From: William Simcock
Sent: 23 January 2019 12:30
To: DCAdmin
Subject: FW: Further Highways comments 92 New North Road.

From: Jamie Turner
Sent: 23 January 2019 10:07
To: William Simcock <William.Simcock@kirklees.gov.uk>
Subject: RE: 92 New North Road.

From: William Simcock
Sent: 16 January 2019 10:10
To: Jamie Turner <Jamie.Turner@kirklees.gov.uk>
Subject: FW: 92 New North Road.

Ordnance Survey, (c) Crown Copyright 2018. All rights reserved. Licence number 100022432

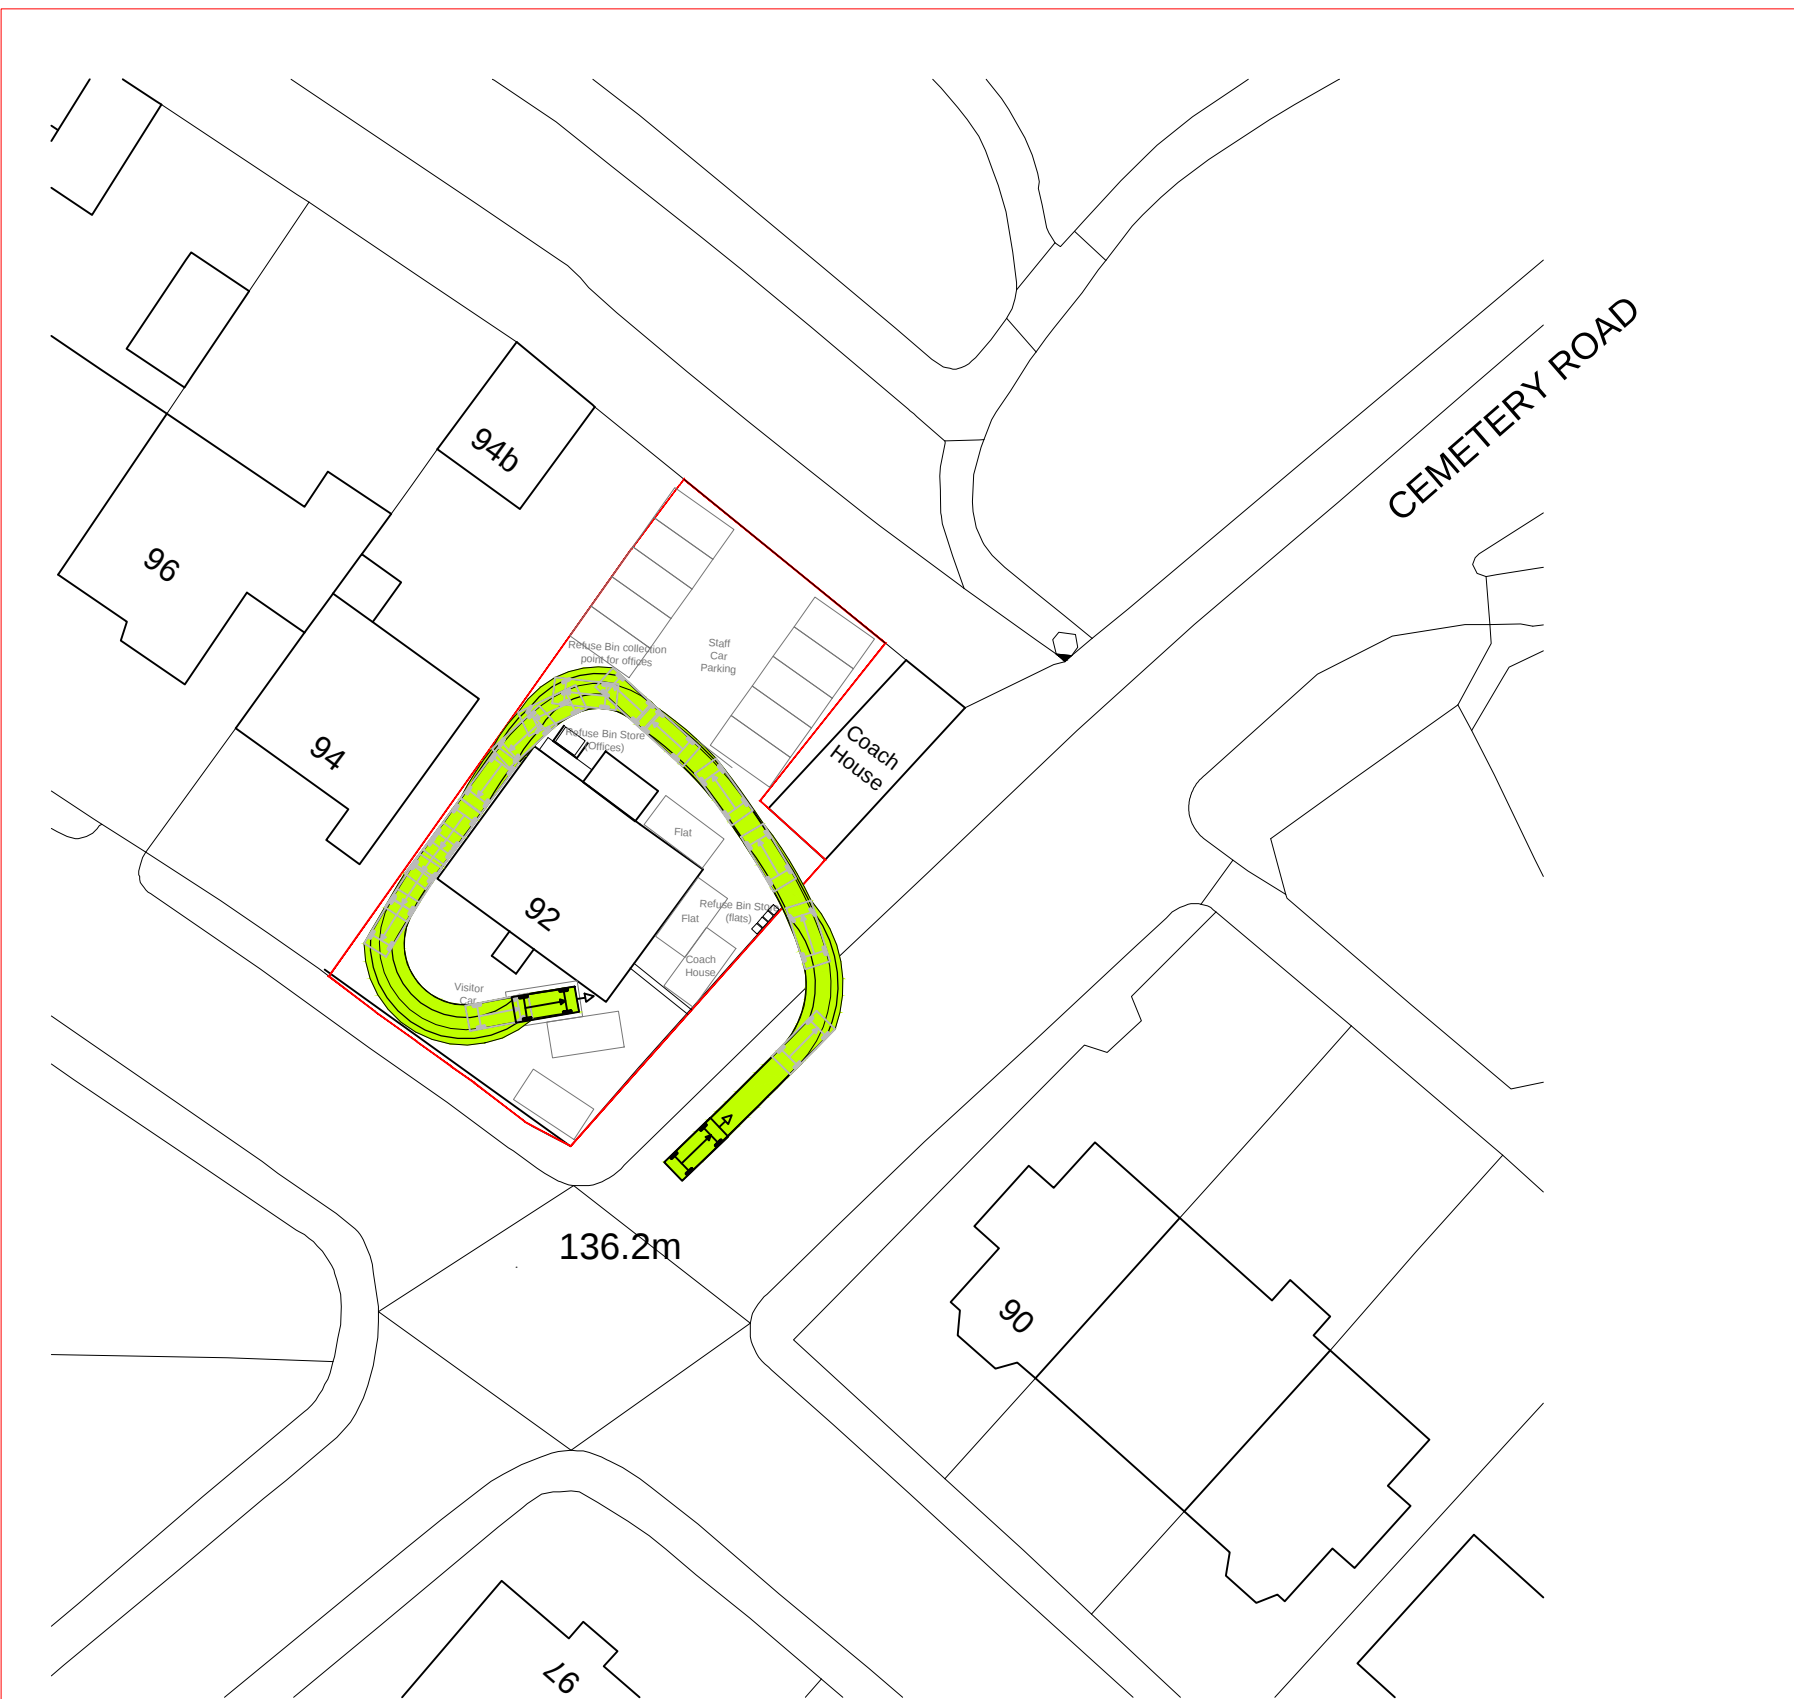
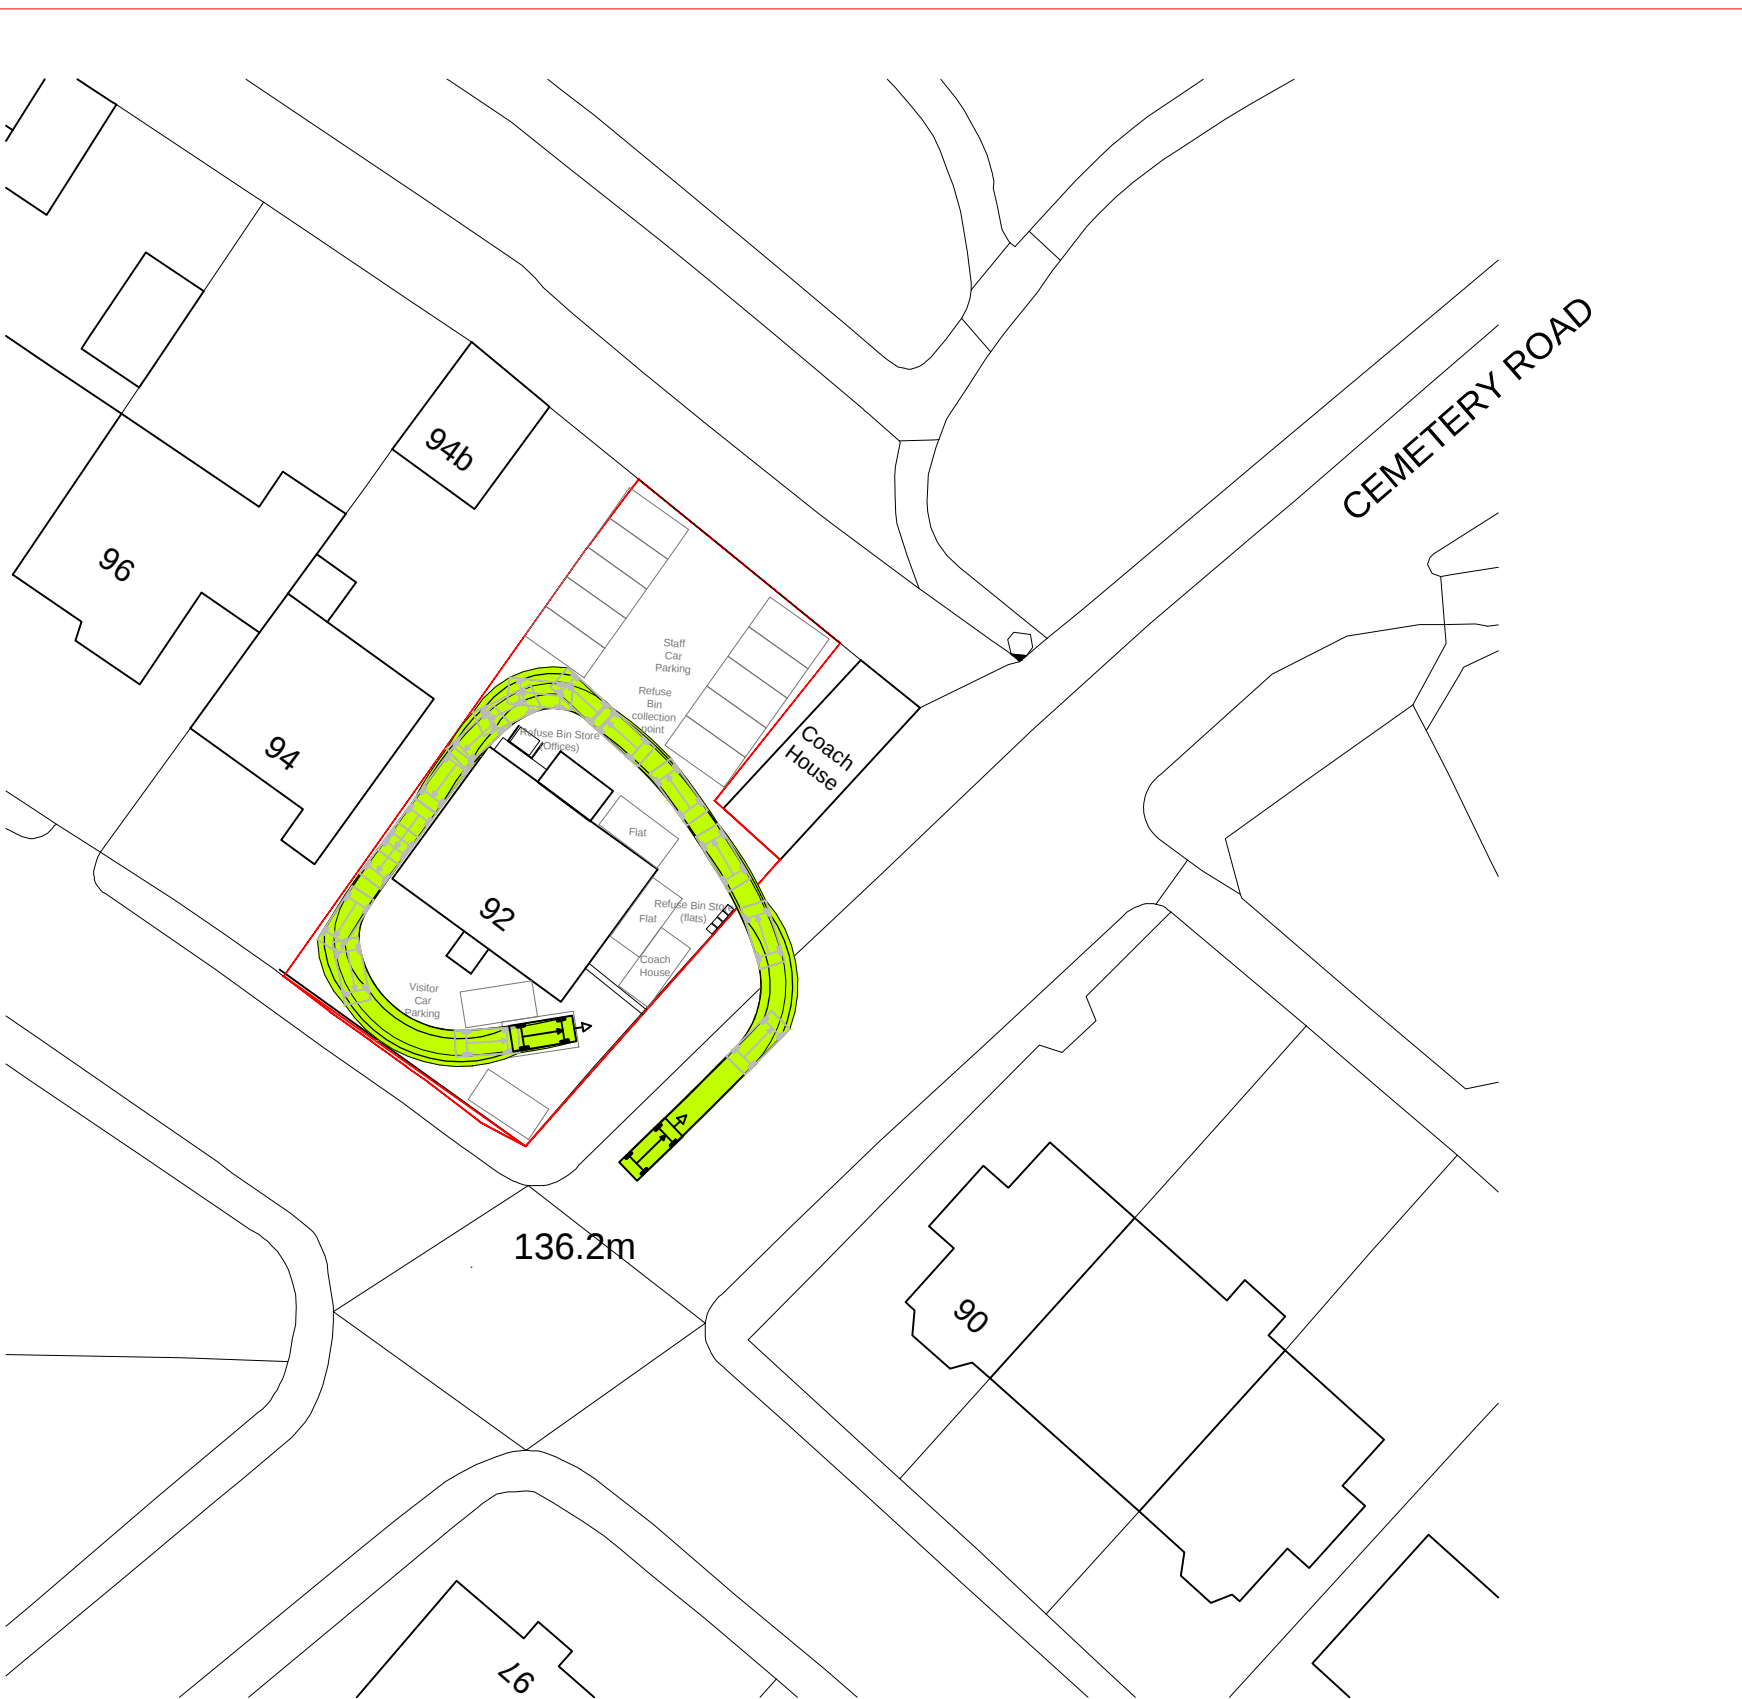
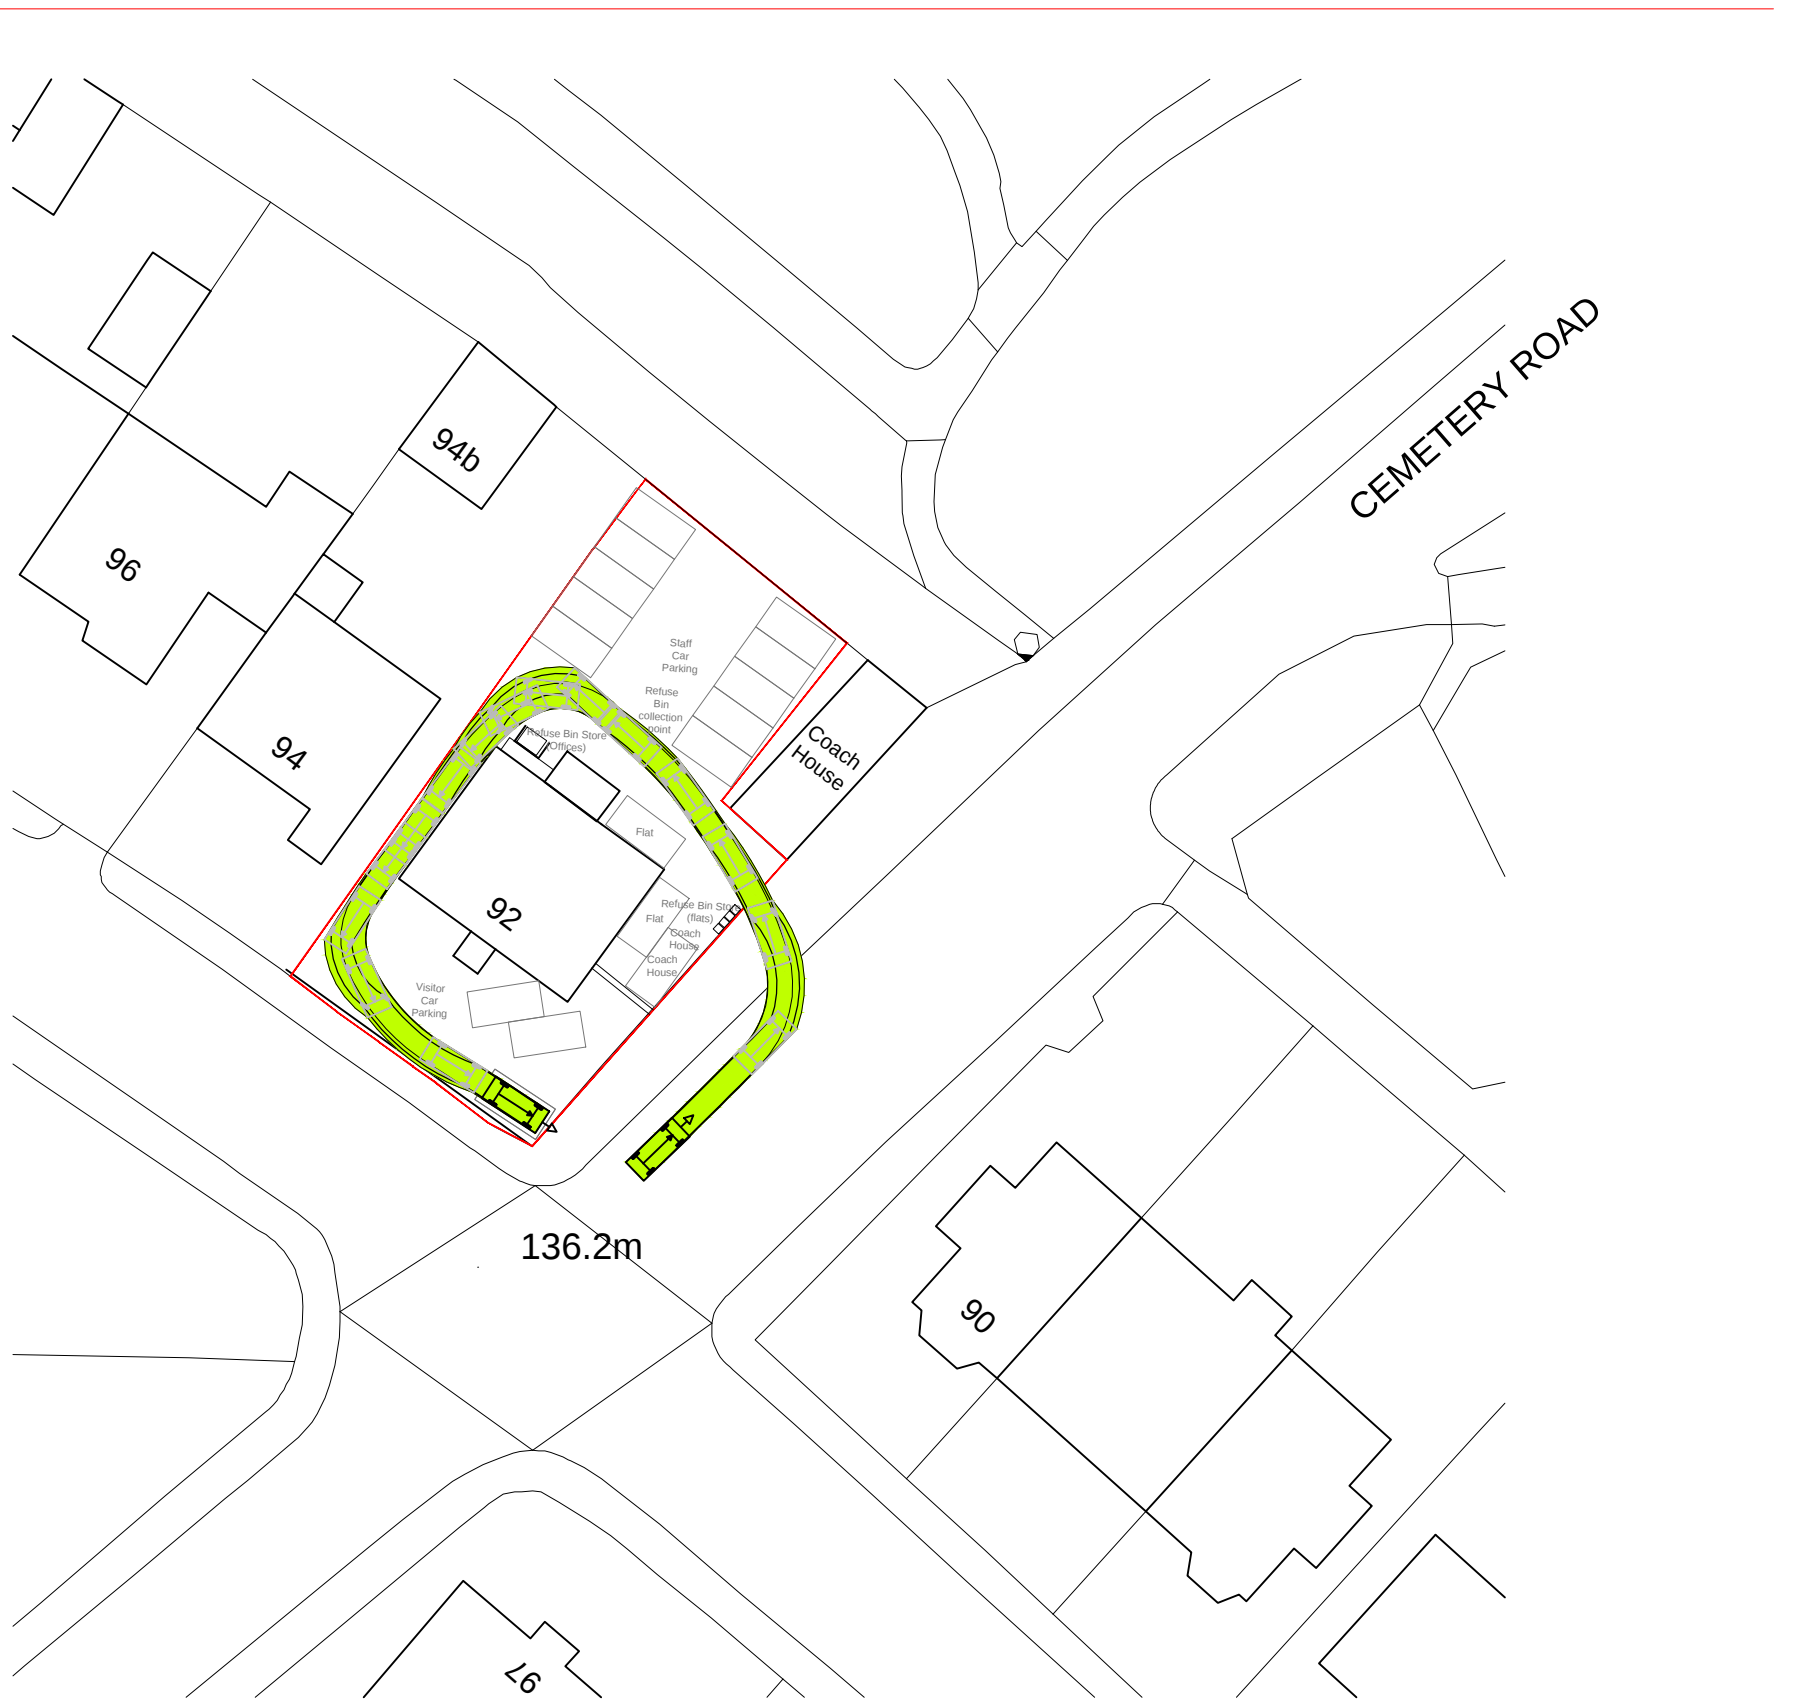
Given the location of the site, I feel the bays to the rear of the site would cover our minimum requirement for off-street parking provision. That said, I believe the front bays are accessible by a regular-sized car without crossing the red line boundary; there is approximately 2.3m of clearance even taking into account the chimney stack.

These are the latest swept paths. One parking space has been deleted. I think the number is more than adequate for a site with good public transport, but I would like your reassurance that the swept paths are okay.

Given the above, the scheme is acceptable from a highways point of view.
